From: Brenda Larsen
Sent: Monday, April 02, 2012 10:24 AM
To: Jeff Watson
Subject: RE: BL-12-00004 Free
Attachments: Free.doc

Re: Free (BL-12-00004)

Brenda Larsen
Kittitas County Fire Marshal
509-962-7000

PROPOSED

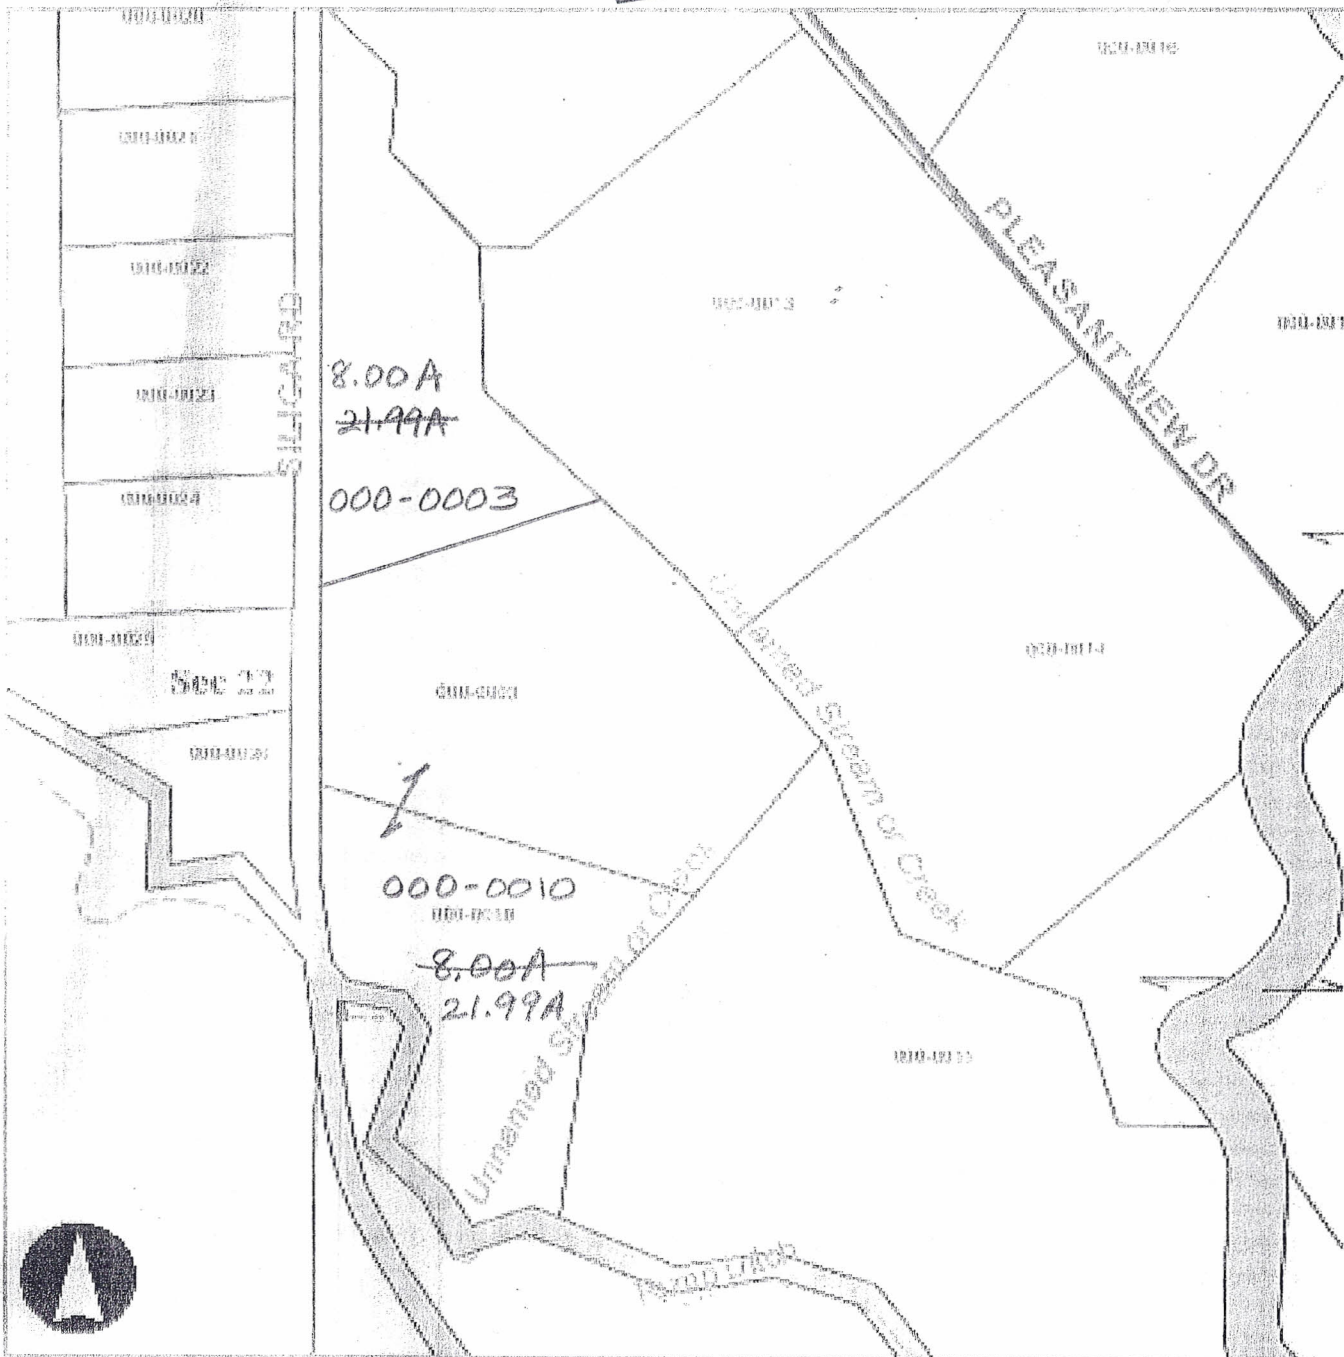
- Ensure that boundary line adjustments do not infringe upon existing structures, to include propane tanks, etc.
- Creation of any additional roads or access must comply with the International Fire Code and KCC Title 12.
- All future development must comply with the International Fire Code.
